APPLICATION NO. 04DRB-01247	PROJECT NO. 1003609
PROJECT NAME TWO FORTY LLC	
APPLICANT / AGENT WILKS Co.	PHONE NO. 888-3066
ZONE ATLAS PAGE H-14	DATE SUBMITTED 8-11-04

APPLICATION NO. 1003609	PROJECT NO. 04DRB01247
PROJECT NAME Two Forty L.L.C. Subd.	
EPC APPLICATION NO.	
APPLICANT / AGENT Jim Wilks	PHONE NO. 888-3066
ZONE ATLAS PAGE H-14	
(SDP for SUB), (SDP for BP), (FINAL PLATS), (MASTER DEV PLAN), (IR) (AA)	
ONE STOP COMMENT FORM LOG

REFERENCE: Plat of Tracts A-1 and B-1; TWO FORTY LLC Subdivision

**PLAT OF
TRACTS A and B
TWO FORTY L.L.C SUBDIVISION**
WITHIN
SECTION 8, TOWNSHIP 10 NORTH, RANGE 3 EAST, N.M.P.M.
CITY OF ALBUQUERQUE
BERNALILLO COUNTY, NEW MEXICO
AUGUST, 2004

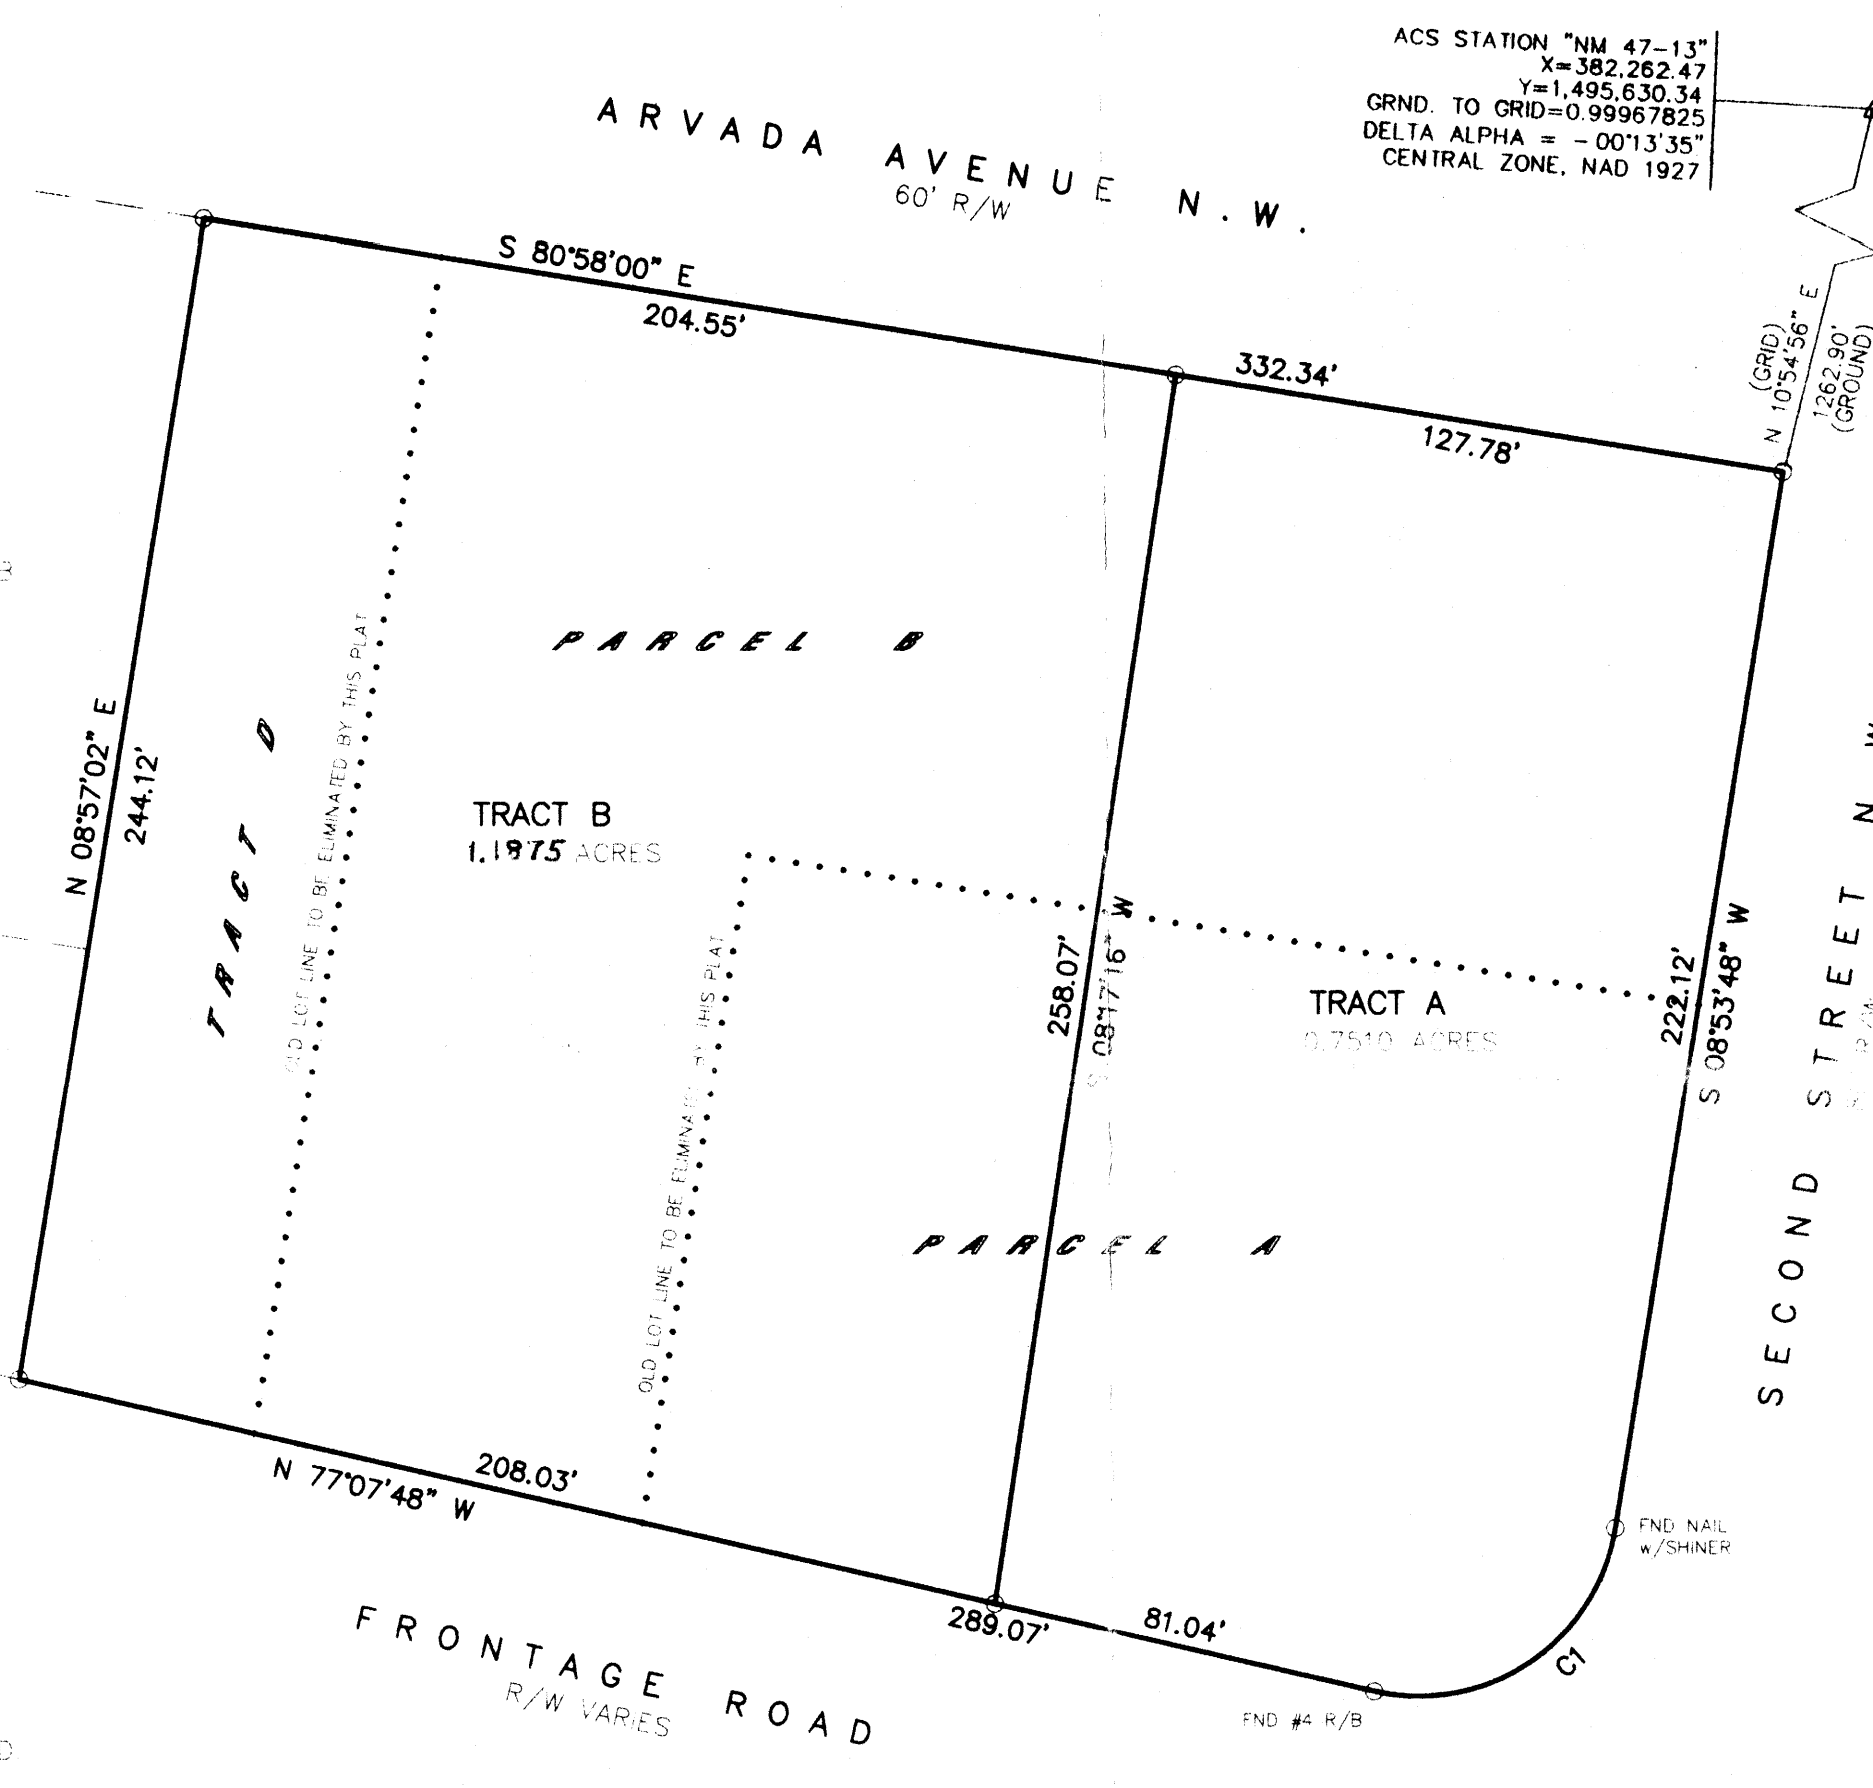
TRANSPORTATION DEV (505) 924-3990		
PLANS DISAPPROVED <i>WG</i>	DATE 8-12-04	DATE
PLANS APPROVED <i>WG</i>	DATE 9-2-04	DATE
COMMENTS:		
① IS PROPERTY LINE 10' FROM FACE OF CURB? ✓		
② SIDEWALKS NEED TO BE REPLACED ✓		
③ NEED TO SHOW THAT ALL PARKING IS CONTAINED ✓ w/ IN PROPOSED LOTS.
